RE: North Harnett Primary School Pre-K
282 North Harnett School Road
Angier, NC 27501

A plan review was received by this office concerning the construction of the above referenced facility. The plans and specifications are approved with the following contingencies:

NORTH HARNETT PRIMARY

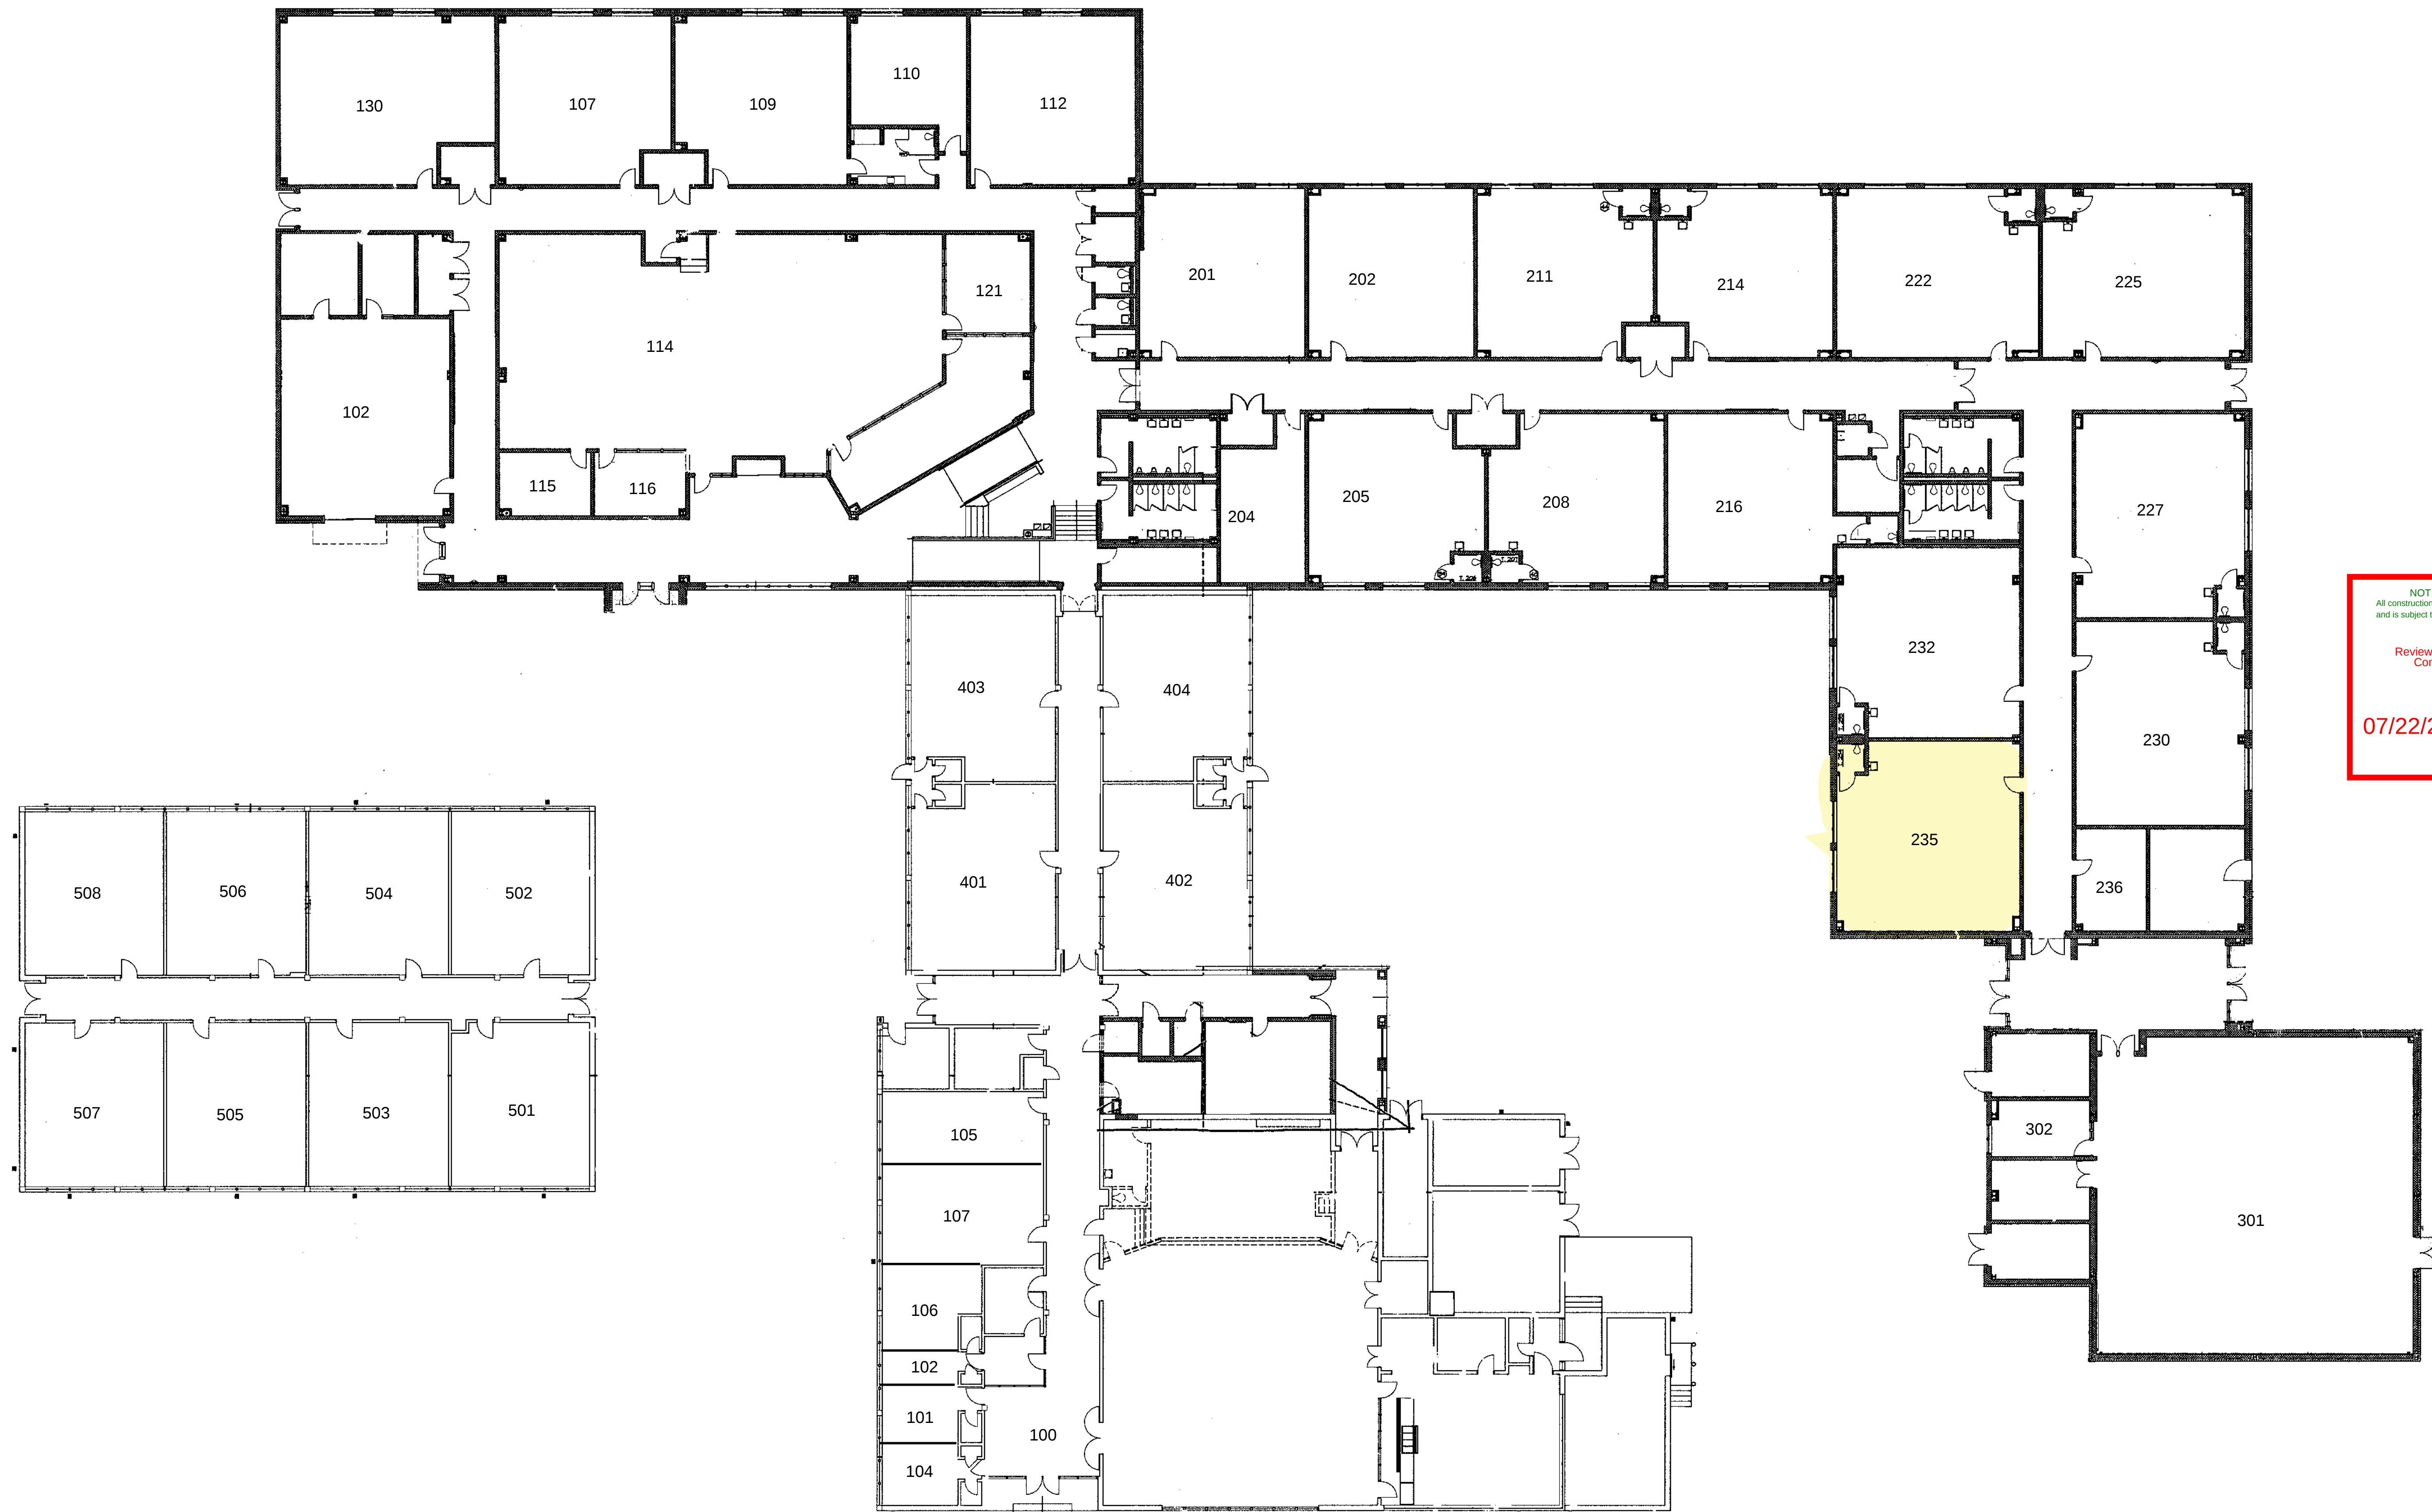
- 1: The hand sink provided in the pre-K classroom, Room 235, has been identified as containing lead-based paint, and must remain intact.
- 2: Any area deemed a lead hazard during the lead investigation that occurred on January 4th, 5th, 6th, 13th, and 27th shall not be approved for use.
